Engineers Comments Regarding Surface Water Drainage

Application Reference:	P/40/25/PL	Reviewer Reference:	ADC/EXT4
Planning Officer:	Amber Willard	Date of Review:	17.09.2025
Site Name:	Sefter Farm Pagham Road Pagham PO21 3PX		
Application Description:	Erection of warehouse extension and remodelling of existing reservoir. This application is in CIL zone 5 (zero rated) and may affect the setting of a listed building.		
Assessment Number:	1 of 2

Application Reference: P-40-25-PL Site Name: Sefter Farm Pagham Road Pagham PO21 3PX	Initial Issue Date: 17.09.2025 Issue Date: 17.09.2025 Reviewer Reference: ADC/EXT4
---	---

DRAWN A Davies
ENGINEER S Doughty
SCALE As Shown @ A1
DATE March 2025
CHECKED SRD
PROJECT NO. 23995
DRG. NO. 103
REV. -

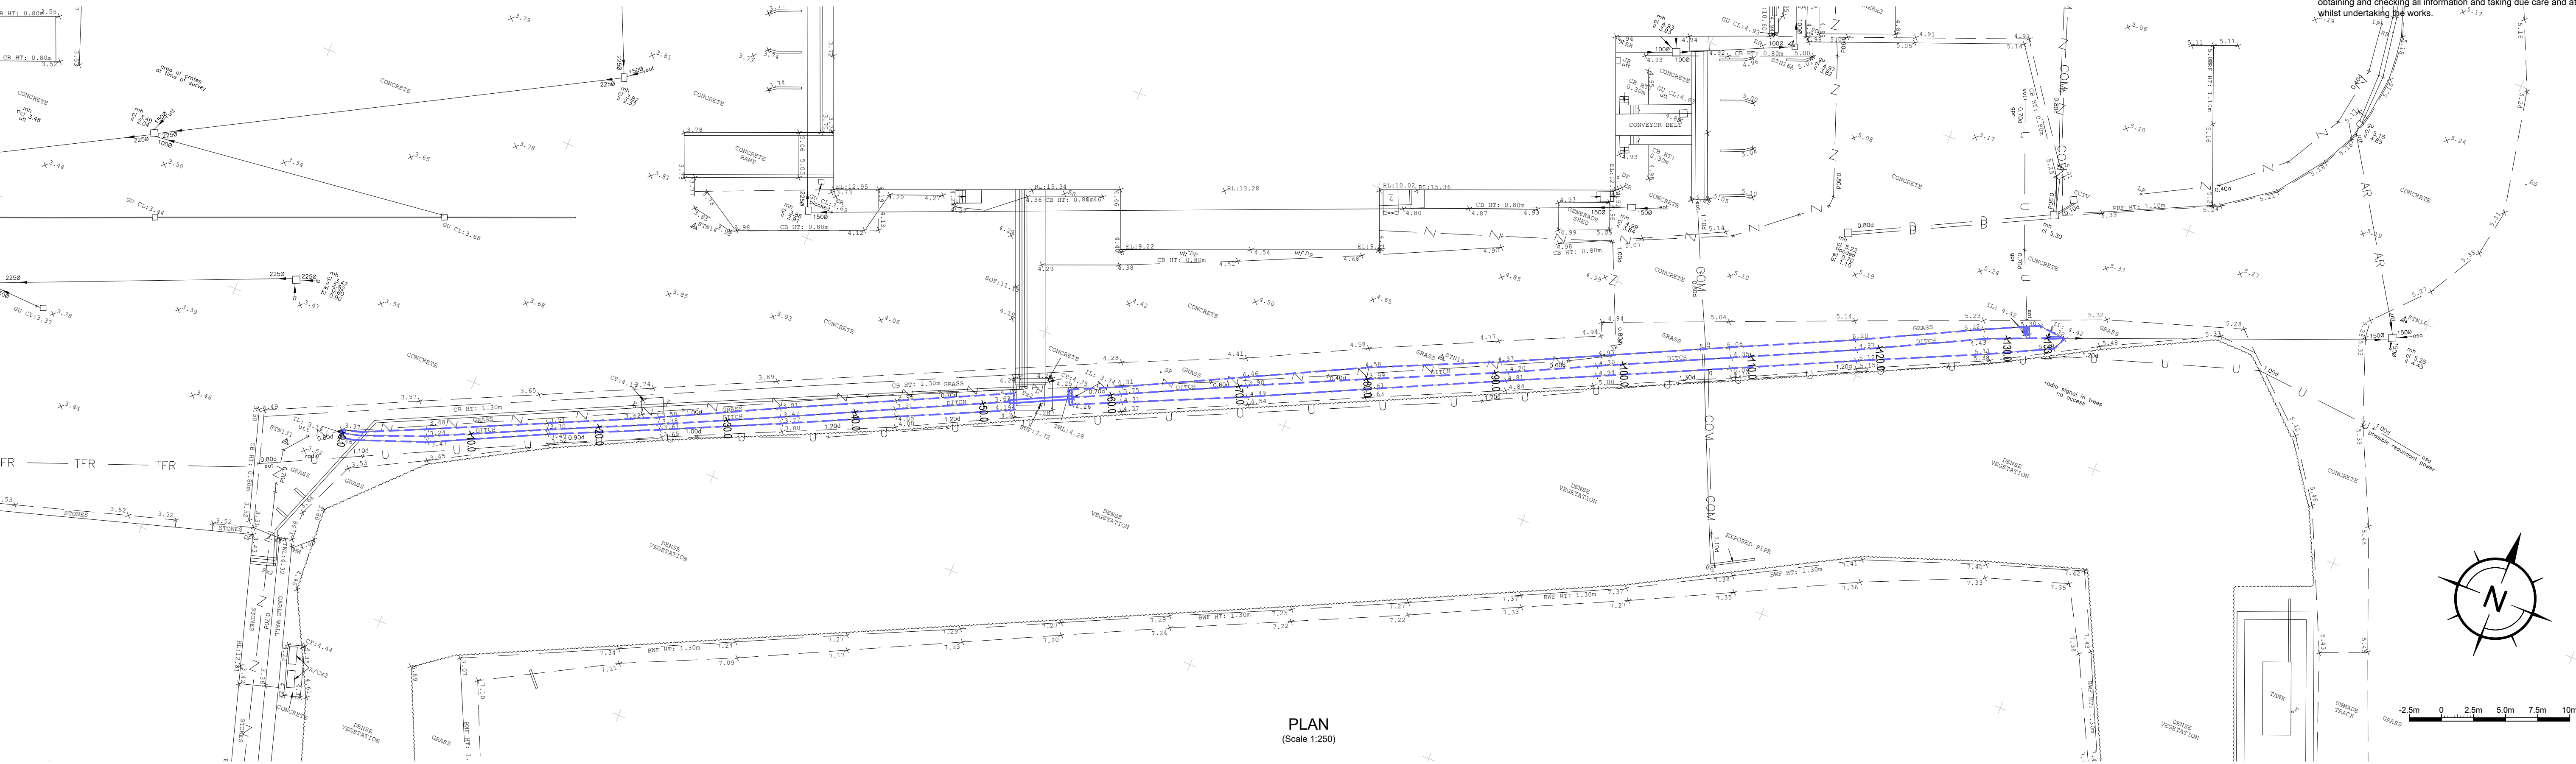
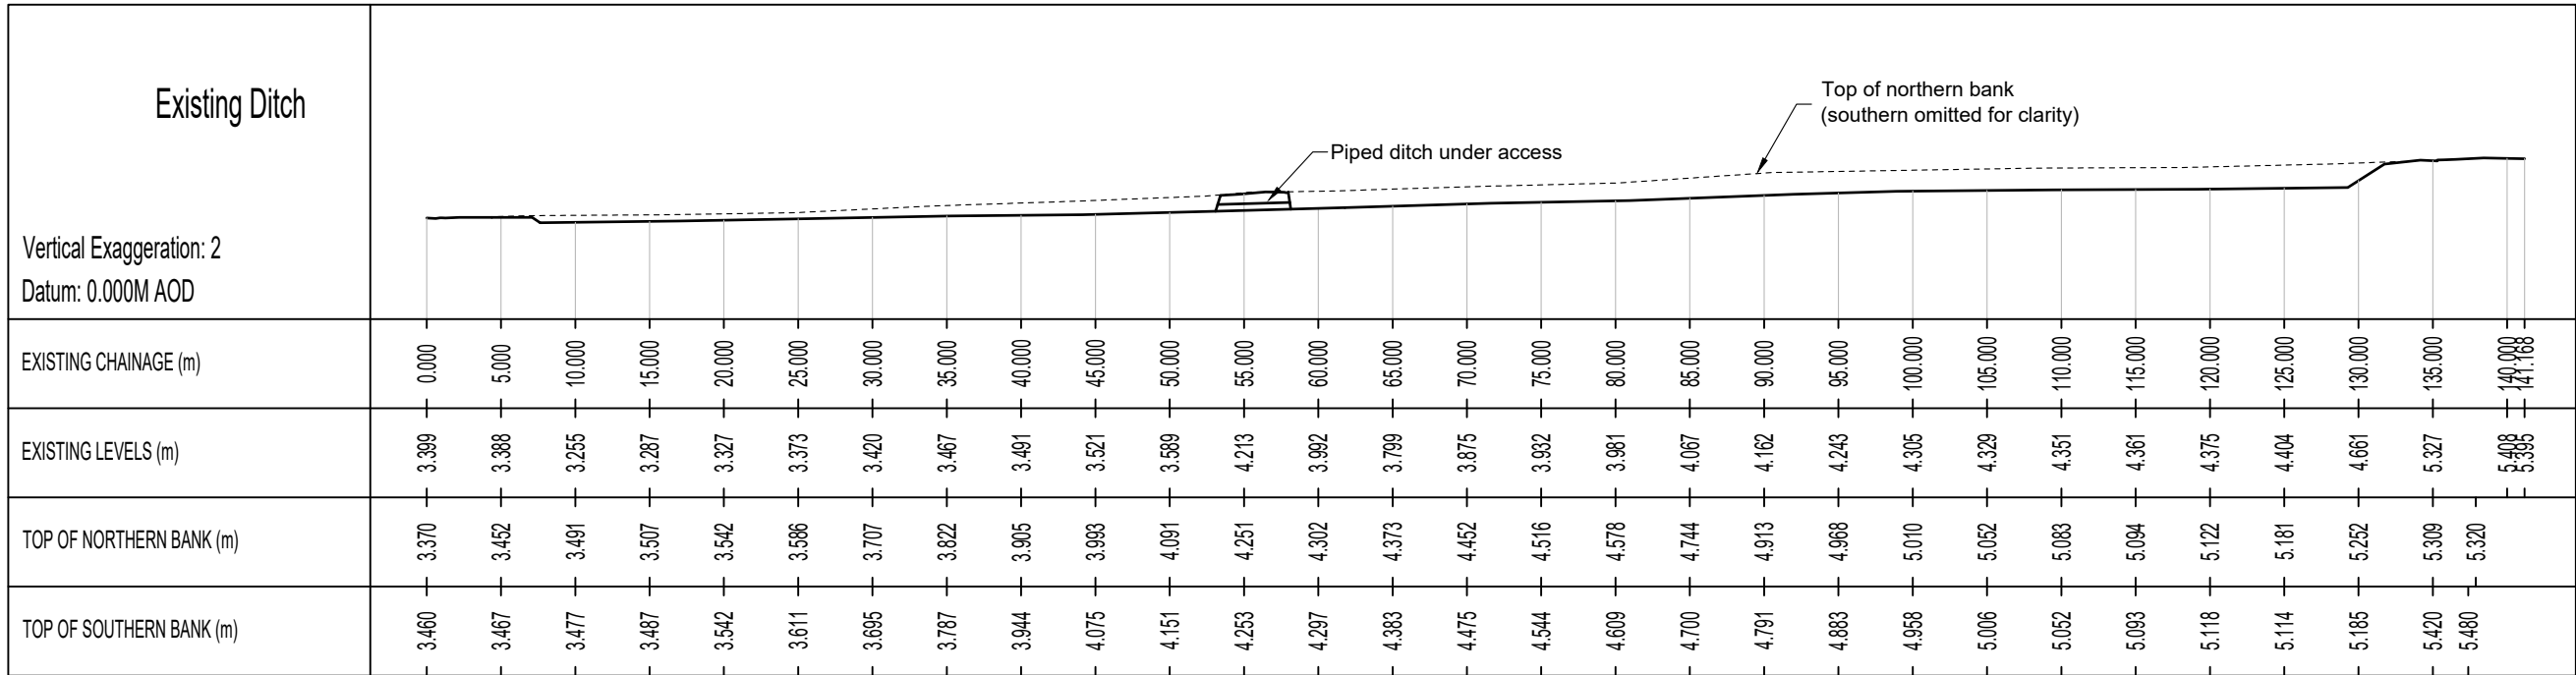
It is noted that there are proposals to divert the existing watercourse. Evidence of positive dialogue over these proposals with the LLFA is required to ensure that these proposals will be acceptable. The applicant will need to obtain an Ordinary Watercourse Consent in order to carry out any works or diversions to this existing watercourse

4.	The diversion of the existing watercourse will require an Ordinary Watercourse Consent. Please also provide evidence of any positive dialogue in relation to agreements in principle regarding the diversion of this watercourse
